# **OXFORDSHIRE COUNTY COUNCIL'S PRE APPLICATION ADVICE ON THE RESPONSE TO CONSULTATION ON THE FOLLOWING DEVELOPMENT PROPOSAL**

**Application No:** 20/CH0003/Preapp

**Proposal:** Advise on highways and transport matters associated with development proposals for a new family resort at a site in Chesterton near Bicester.

**Location:** B430/ B4030 Middleton Stoney junction, Bicester.

Title:
Indicative Mitigation Works

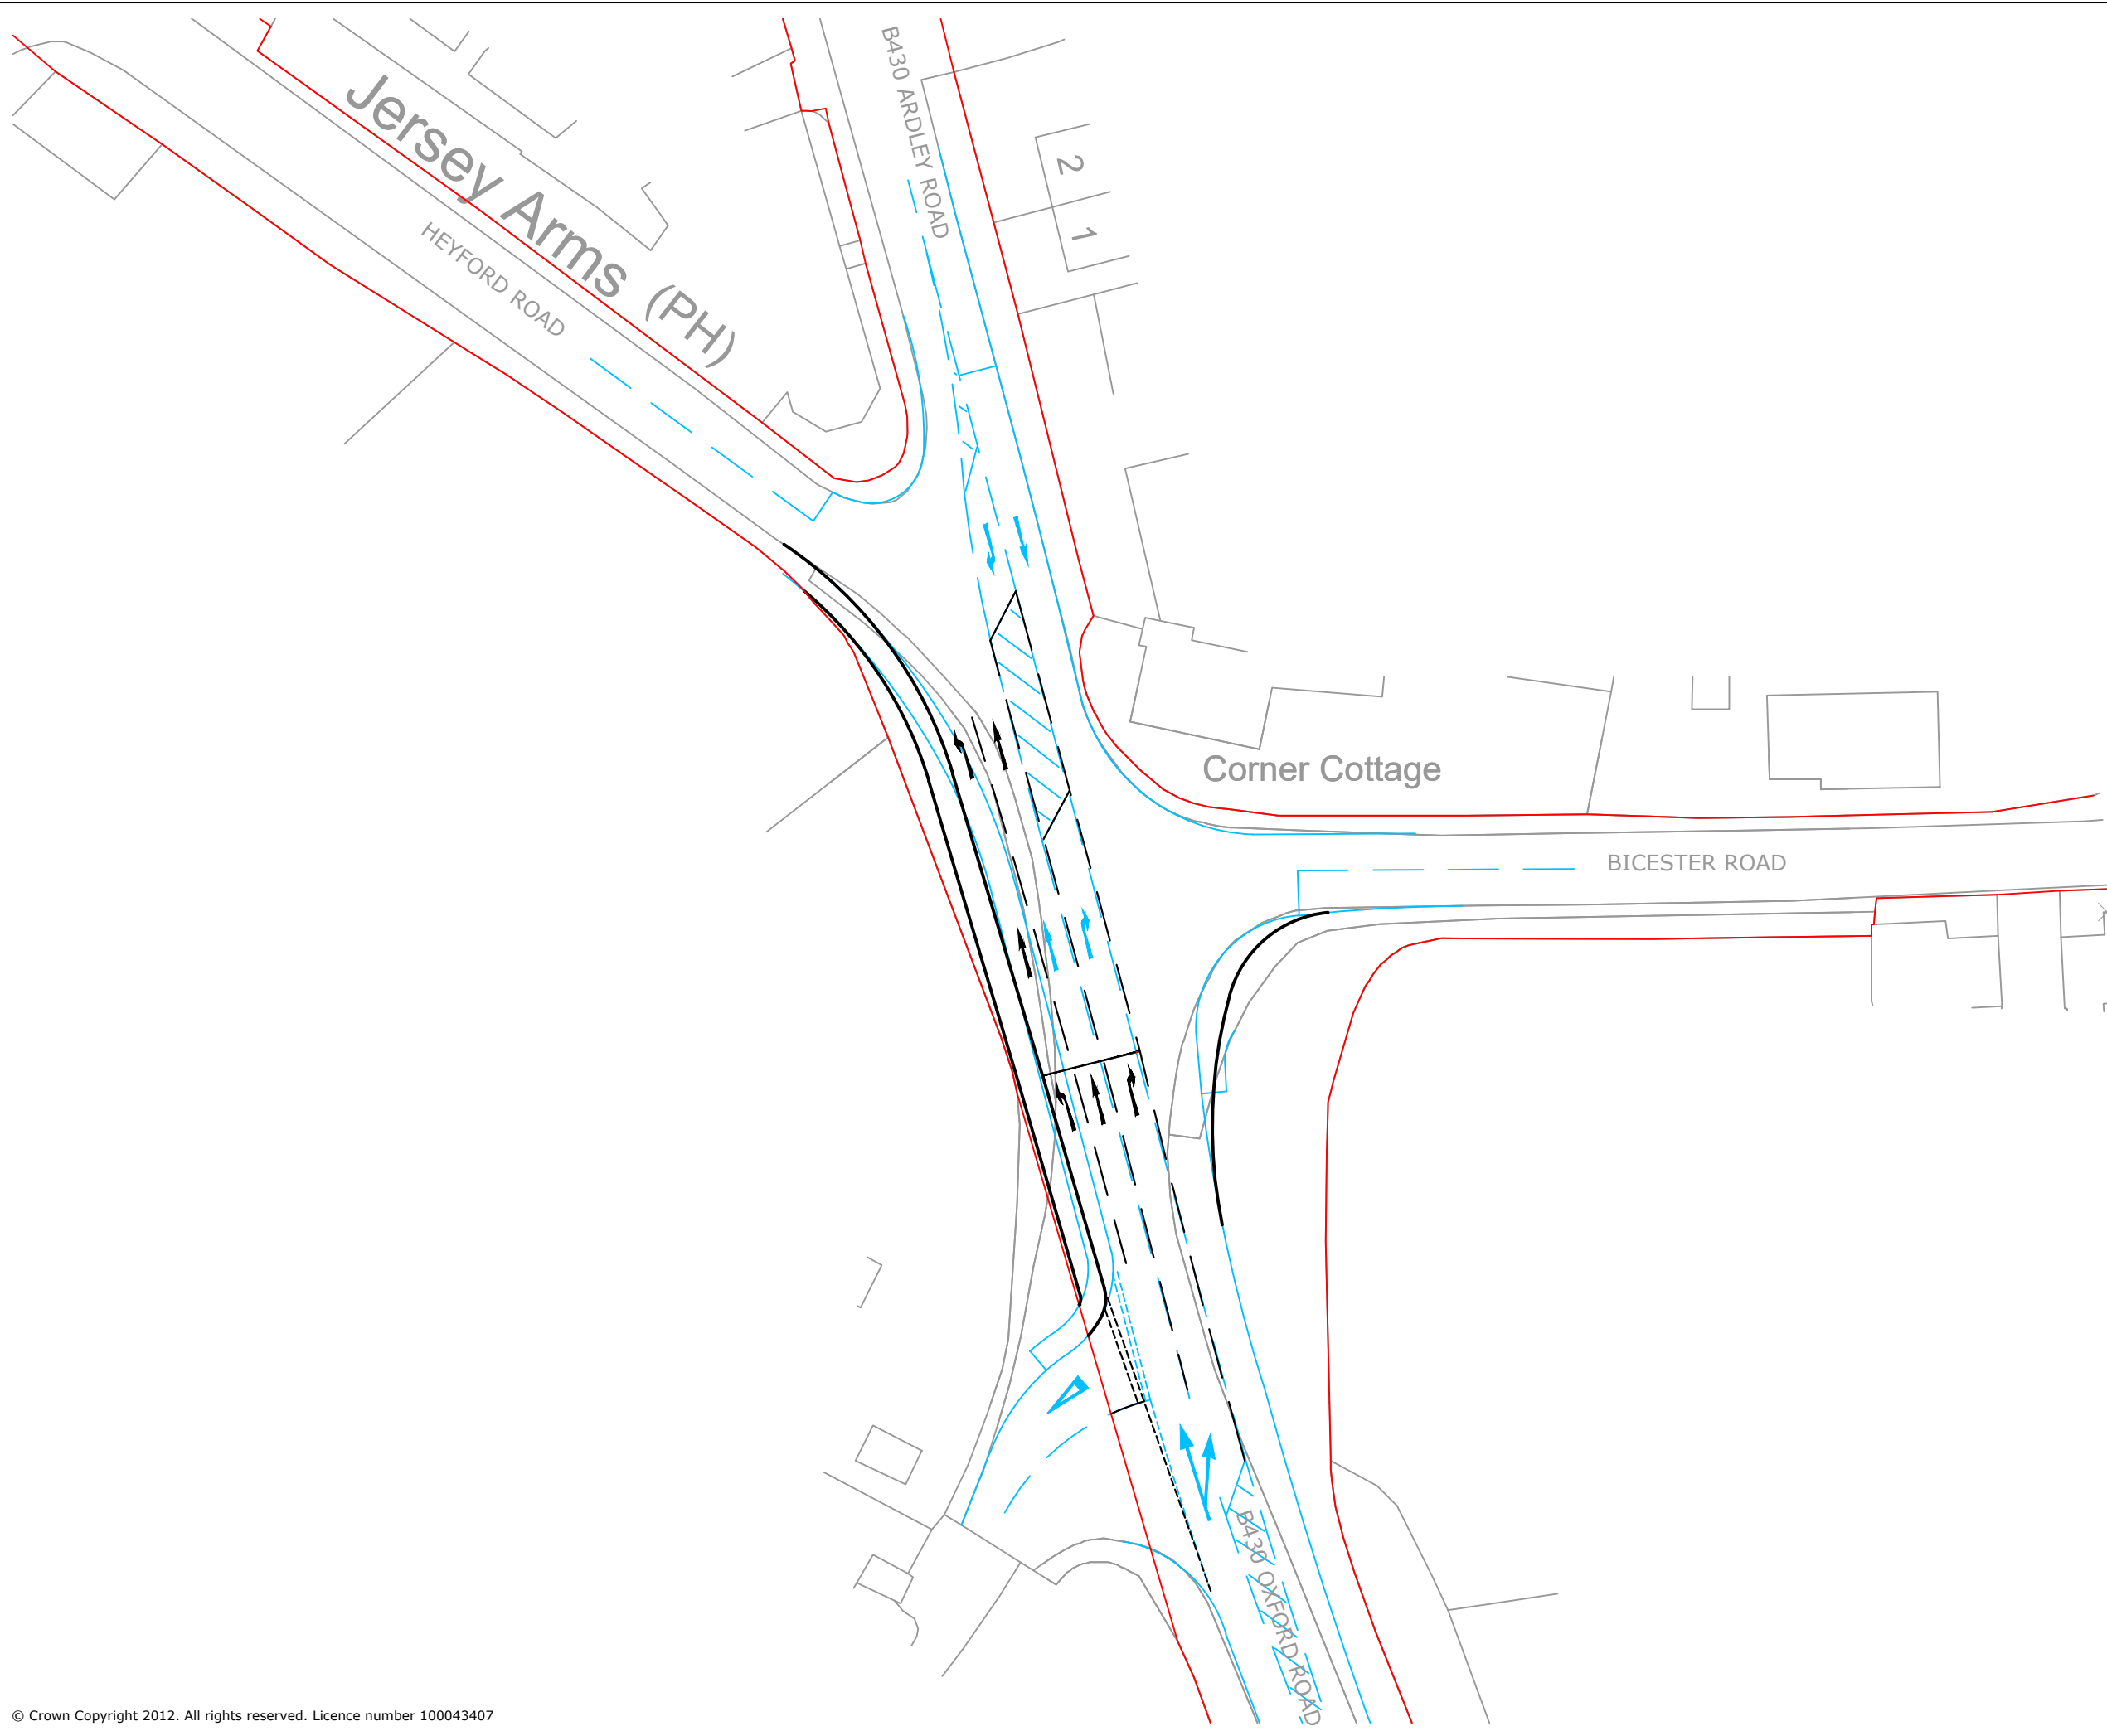
The second Motion analysis is modelled on the layout proposal as shown in drg. no. 1803047-17 Rev. B, with the Great Wolf Resort peak hour generated traffic being added to the flows.

The comparative outputs show that, despite the expansion of the junction to include a left turn only lane from the northbound B430, the performance of the junction remains over the theoretical capacity and is marginally worse with the Great Wolf generated traffic and mitigation. The Degree of Saturation (DoS) increases by just over 1% on the B430 southbound and B4030 westbound (titled B4030 (east) in the Tables), whilst the Mean Maximum Queue (MMQ) increases by 9% and 8% respectively.

Given the results of the analysis, it is not considered that the proposed Great Wolf mitigation scheme will reliably provide a signalised junction that will alleviate the current severe congestion or will improve upon the consented Heyford Park mitigation scheme.

The proposed layout will necessitate a significant change to the facilities for pedestrians wishing to cross the B430. With the current arrangement, which is largely unaltered in the Heyford Park mitigation scheme, the informal crossing point is behind the stop line for northbound B430 traffic, which means that pedestrians may have to cross between vehicles in a queue (two lanes in the case of Heyford Park mitigation) of stationary vehicles. The proposed Great Wolf mitigation incorporates a pedestrian refuge at the centre of the junction, allowing pedestrians to cross in two stages. However, the waiting area on the east side footway is very narrow, meaning that any waiting pedestrians would be uncomfortably close to passing or turning vehicles, particularly HGVs. Furthermore, the footway to the north is even narrower as the kerblines are particularly close to the highway boundary.

It is appreciated that there is no identifiable pedestrian (or cyclist) crossing point that would accord with current standards. At this stage, OCC are neutral about replacing the existing crossing point with one that allows improved crossing opportunities but has constrained access on one side.

Motion have separately supplied a version of the Indicative Mitigation Works drawing (Rev. C) that is marked up to illustrate the areas of proposed widening over and above the Heyford Park scheme (see Appendix A). This shows further encroachment into the south-east verge

and the footway being positioned up against the boundary wall on the west side, with nearly all the grassed verge being removed on this side.

Whilst it is agreed that the proposed scheme falls entirely within the highway boundary, because of the widening which brings the carriageway closer to properties and reduces verges, the environmental impacts would need to be considered before such a scheme could be agreed or implemented. The scheme has potential impacts on air quality, noise and vibration, and heritage. Consequently, the scheme may not be considered to be deliverable if the environmental impacts are not acceptable.

Overall, OCC are unable to confirm that their previous objection to the full application has been resolved.
